Our Ref: FP/197/19/PL
Your Ref:

Town & Country Planning Act 1990 (as amended)
Town and Country Planning (Development Management Procedure) (England) Order 2015
Application for Planning Permission

Development The proposal consists of a glazed corridor link between the Infant and Junior schools, an extension to the staffroom and internal alterations which combine the administration areas so the building functions as one school.

Location Bishop Tufnell C Of E Junior & Infant School Pennyfields Felpham

drawing: SITE PLAN AND BLOCK PLAN

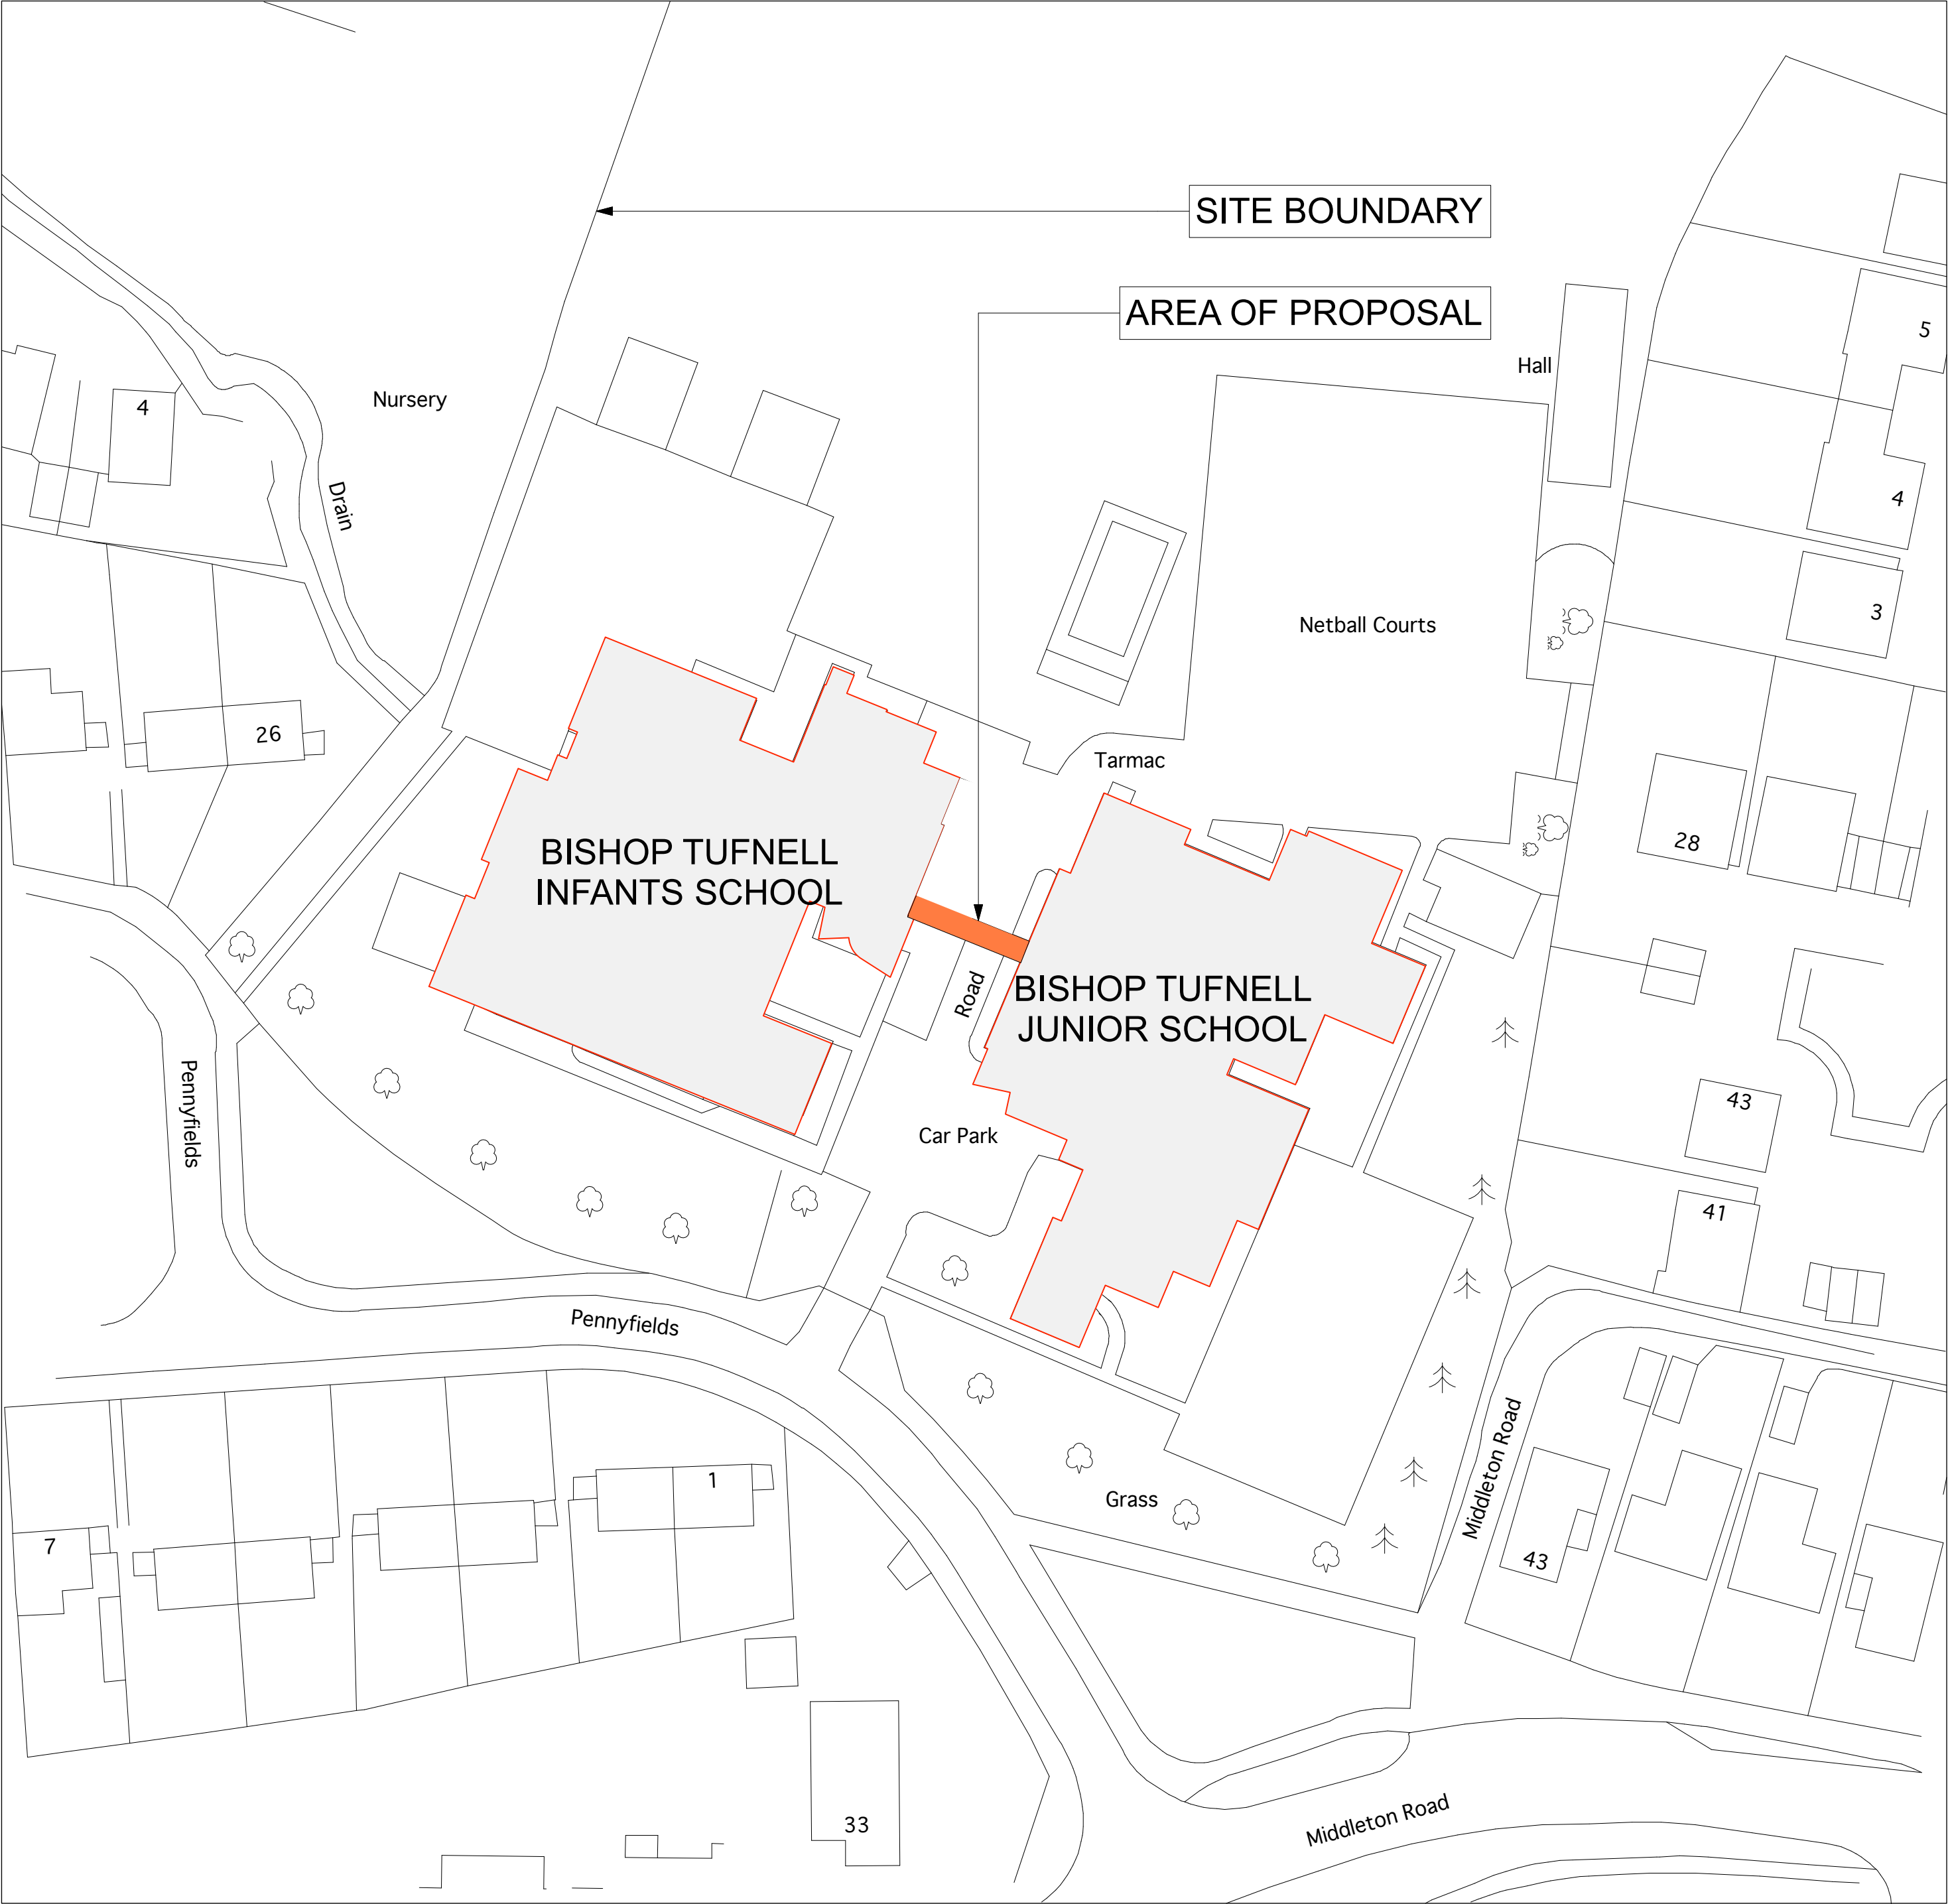
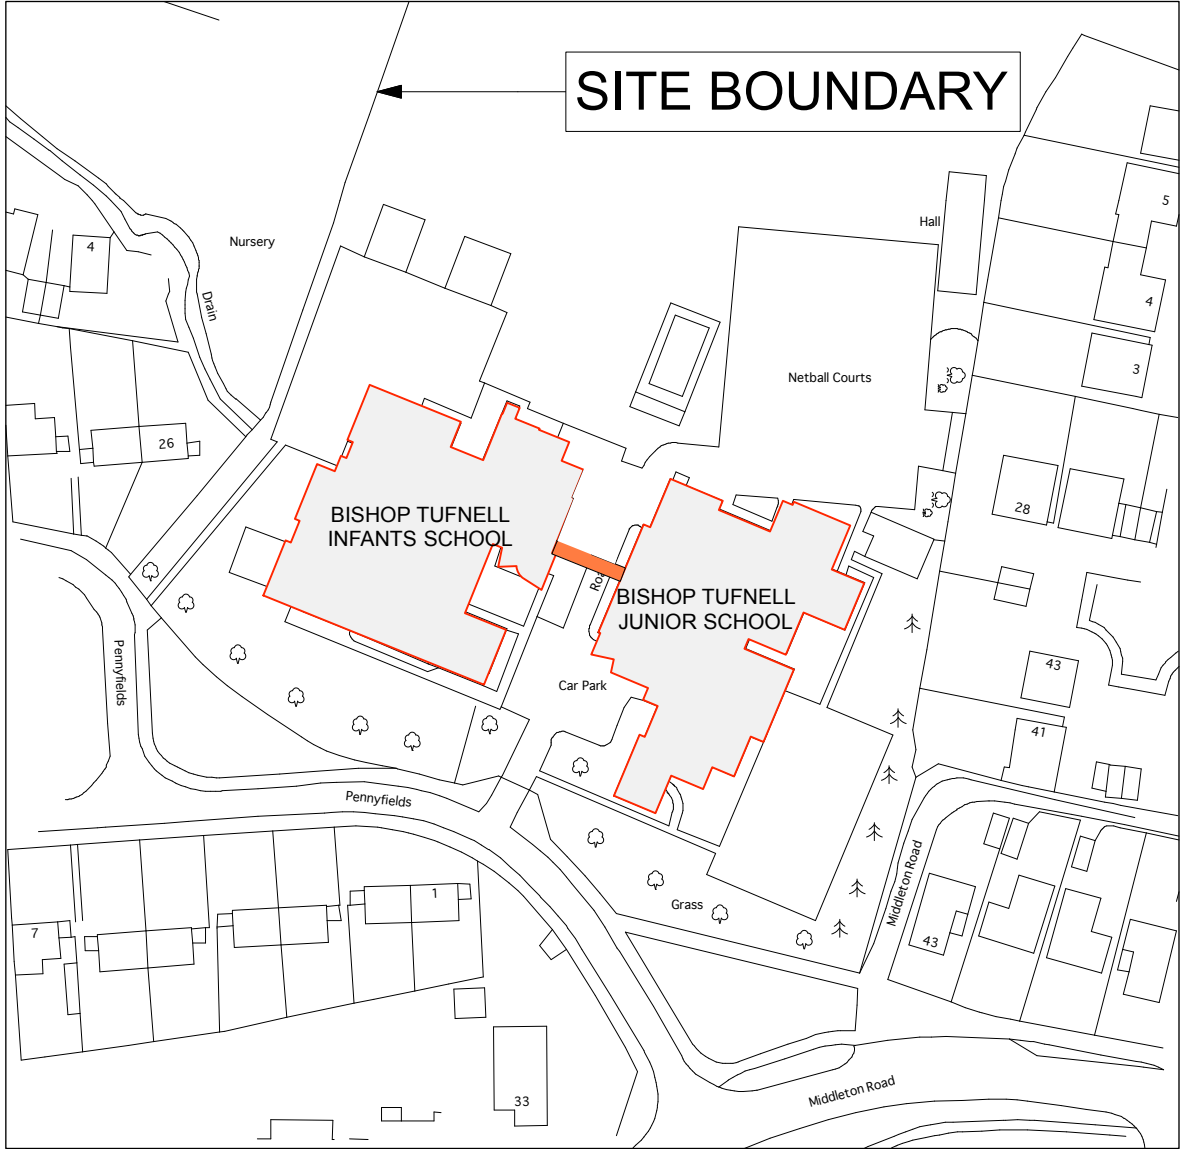
Location Plan Amend

Please provide two named roads.
